City of Portland, Maine - Building or Use Permit Application

Permit No: 2012-65708	Issue Date:	CBL: 032 I021001
--------------------------	-------------	---------------------

has permission to **Office renovations to 3rd/4th floors.**

Proposed Use: Same: lower level rear restaurant - 1st floor retail and offices on 2, 3, 4 floors	Proposed Project Description: Office renovations to 3rd/4th floors.
-----------------------------------------------------------------------------------------------------	------------------------------------------------------------------------

THIRD FLOOR PLAN - 4530 SQ FT
 SCALE: 1/8"=1'-0"

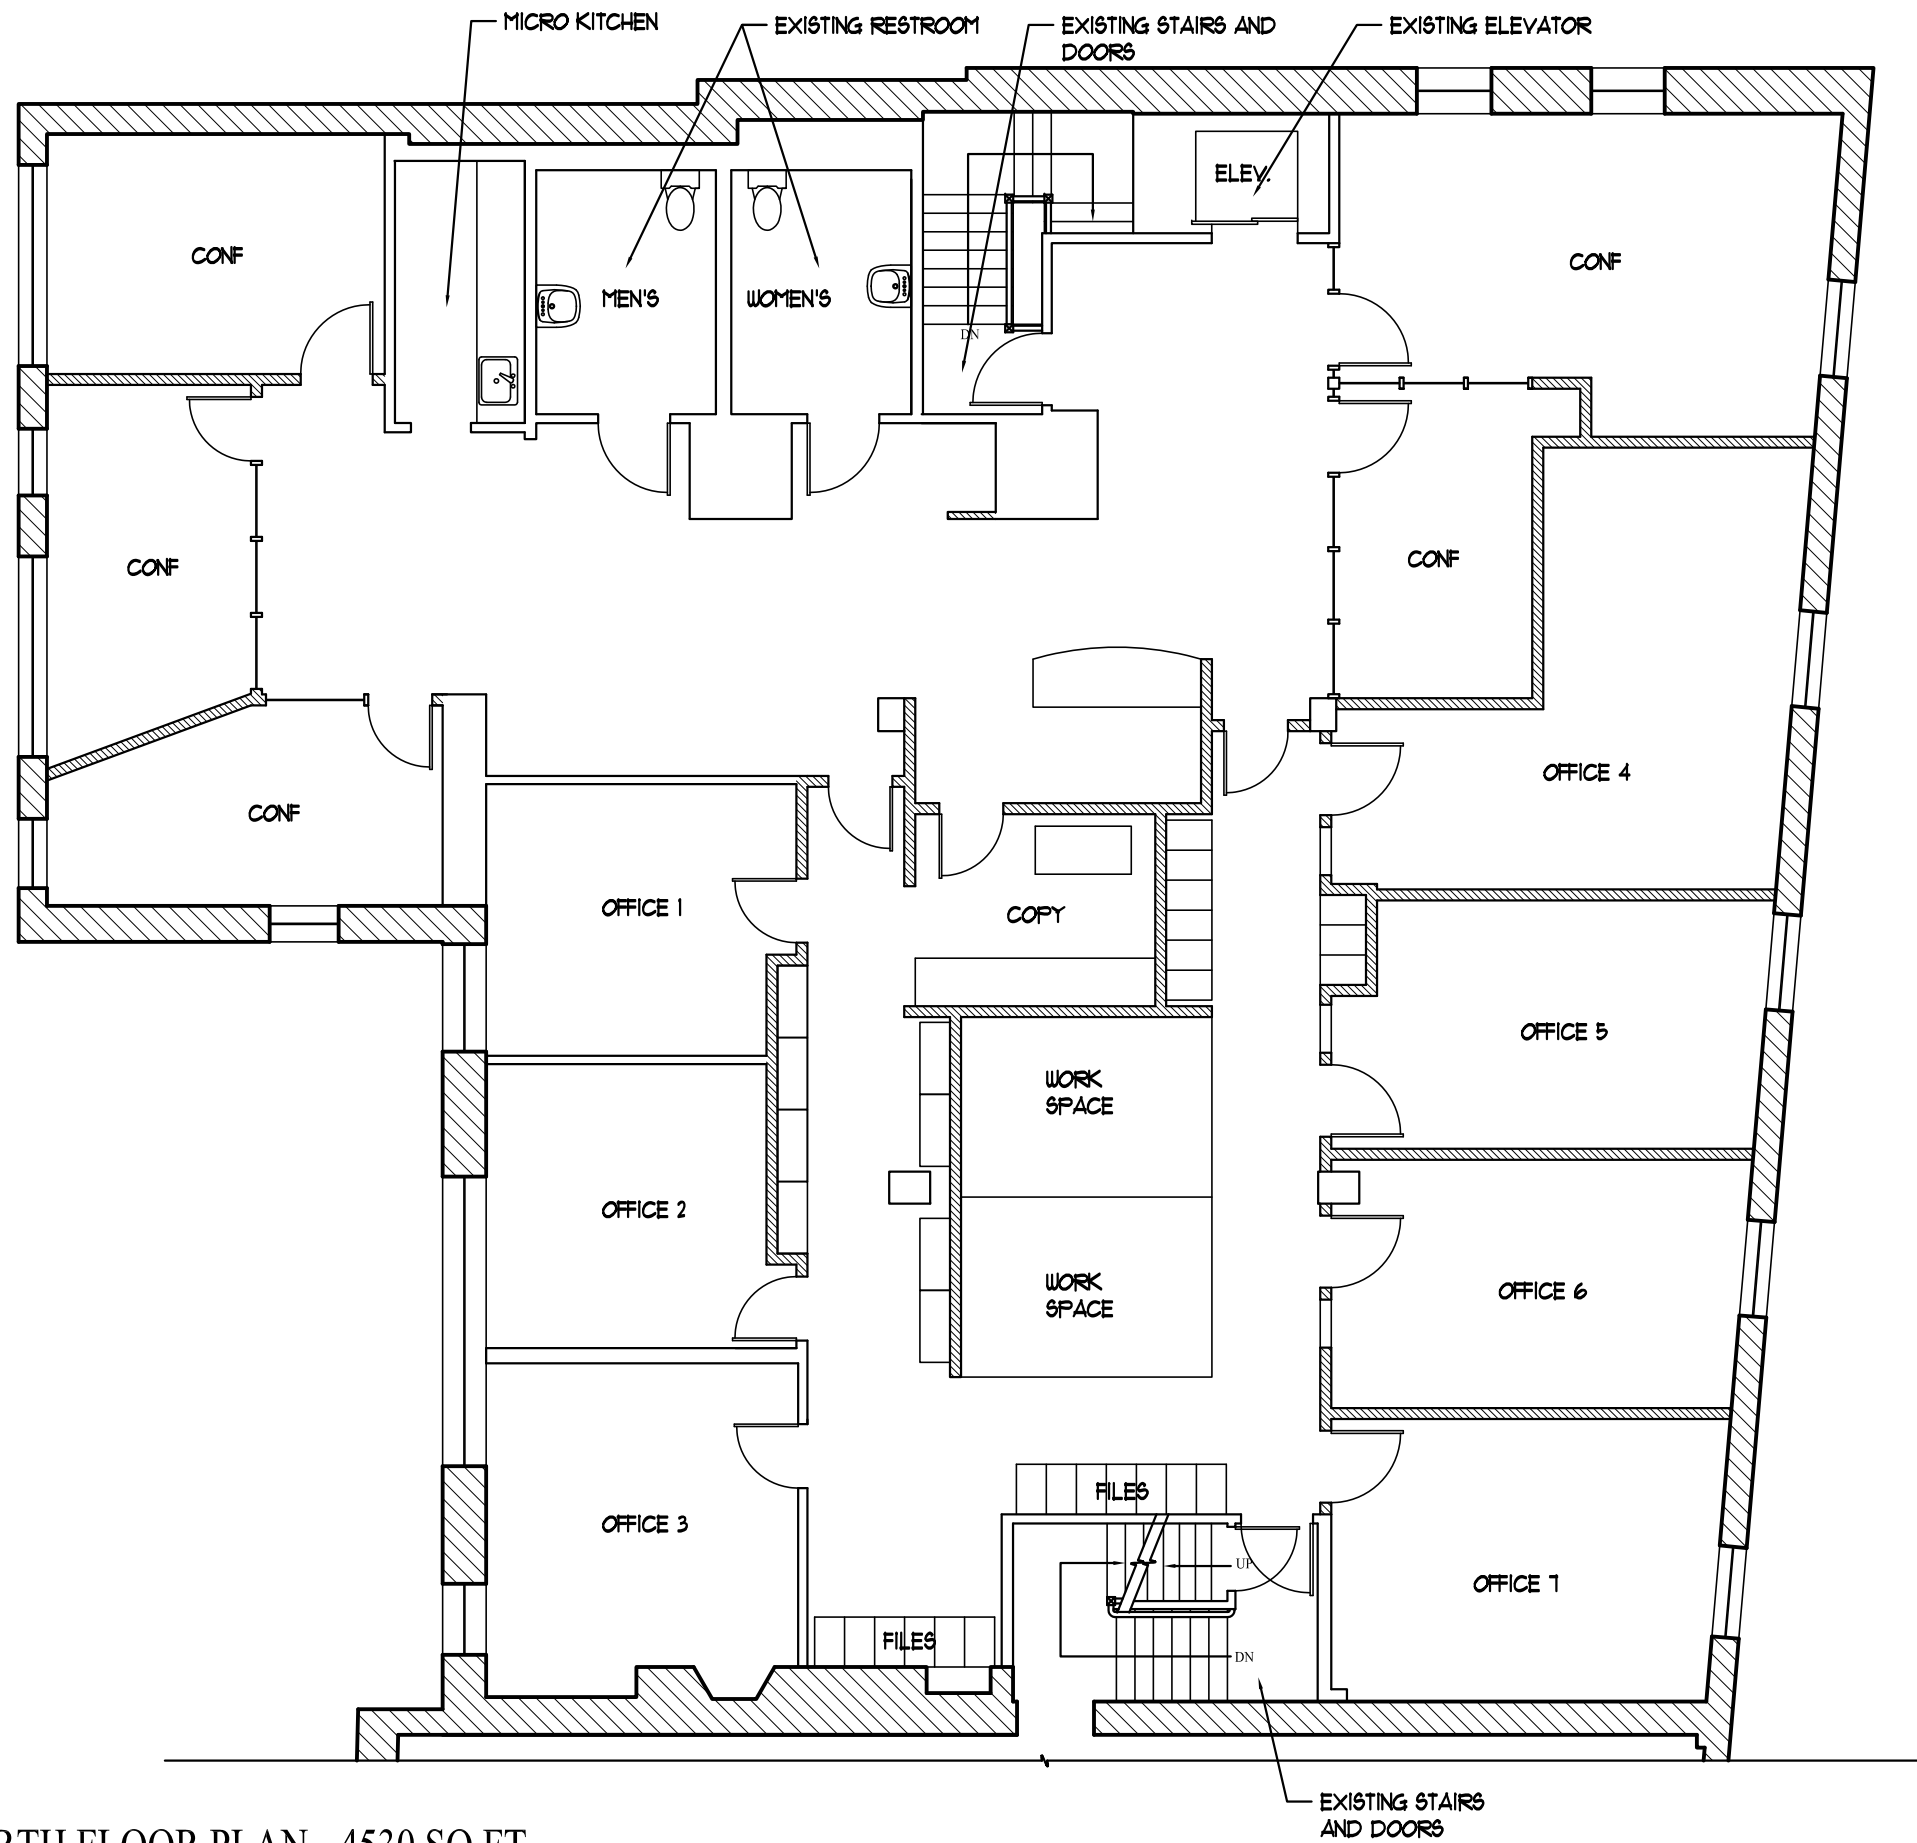
- 6) The glazed wall panels shall meet the loading requirements of IBC Sec. 2403 and Chap. 16.
